Online Comment

Application H18-1242-25
Location Sutton Bridge Memorial Park Sutton Bridge Spalding PE12 9SD
Proposal Construction of new MUGA playzone for football basketball and netball with associated fencing and lighting

Name Diane Fairchild
Address Conservation Assistant (Tree Preservation) Planning & Development

DRAWING TITLE:
Tree Protection Plan.

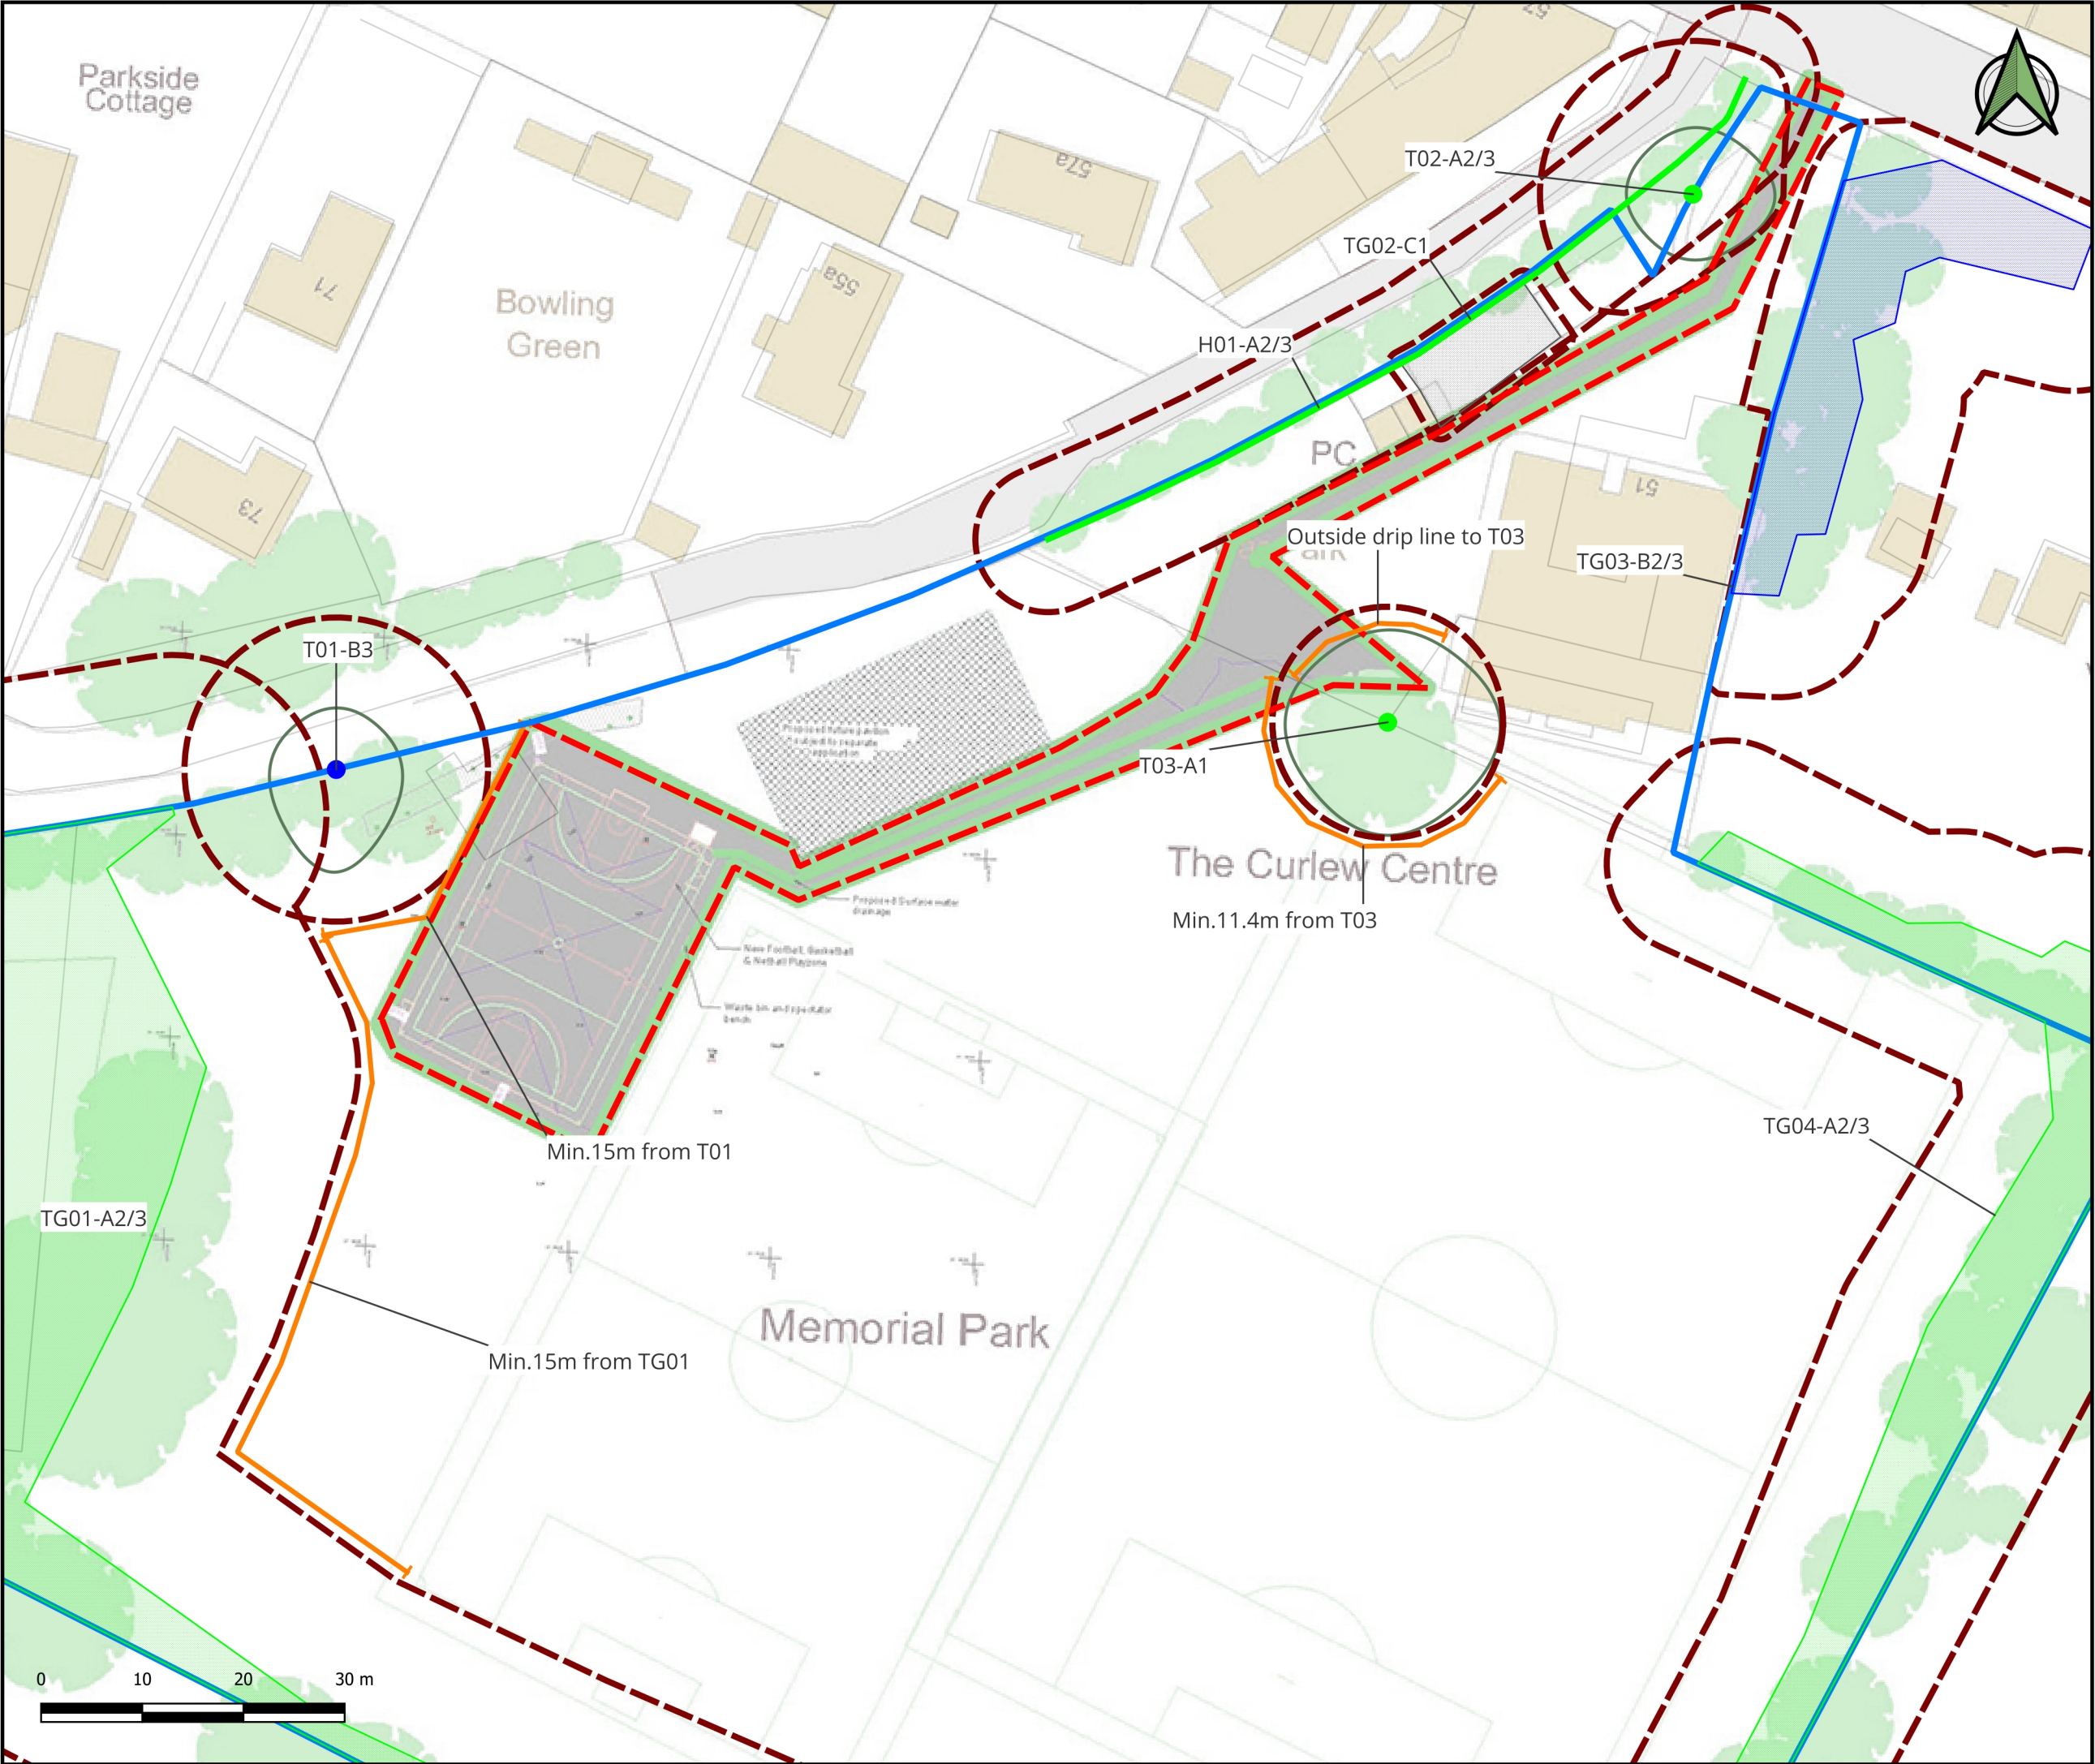
The current proposal shows a drain run to be constructed within the Root Protection Area of the tree. This will cause extensive root damage, which when combined with the effect of the tarmac over the roots, could be seriously detrimental to the wellbeing of the tree.

The drain run(s) should be diverted so as not to cross the roots of the tree. It is likely that the tree may benefit from access to a limited amount of extra water, such as a soakaway outside of the actual Root Protection Area, as oaks are high water demand trees.
